Observations By:	KC, Crime Prevention
Application No.	2024/90058
Proposed Development:	Reserved Matters application, including the considerations of appearance, scale, layout, and landscaping, for the erection of 67 dwellings, pursuant to outline permission 2020/92307 for the erection of residential development (up to 75 units) and the discharge of conditions 7 (include a Written Scheme of Archaeological Investigation (WSI) and Designer's Response), 8 (Foul and Surface Water Drainage Strategy), 9 (flood routing), 10 (mitigatory tree-planting), 11 (cycle parking), 12 (Arboriculture Assessment), 13 (Ecological Design Strategy), 14 (Ecological Impact Assessment), 15 (noise impact assessment)
Location:	Penistone Road/, Rowley Lane, Fenay Bridge, Huddersfield, HD8 0JS
OS Map Reference	SE 418746.693 414496.8166
Applicant/Agent:	Johnson Mowat
Class:	Small Major Developments

Review

PENISTONE ROAD, FENAY BRIDGE
5.6 SITE LAYOUT AND DETAILED ANALYSIS
BOUNDARY TREATMENT PLAN

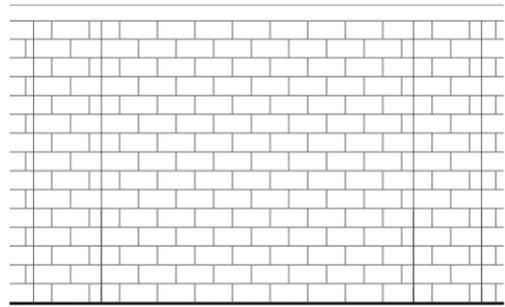
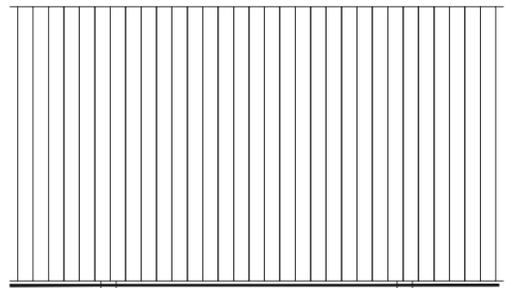
Boundary / Perimeter security – I have noted the proposed boundary plan, and it is acceptable.
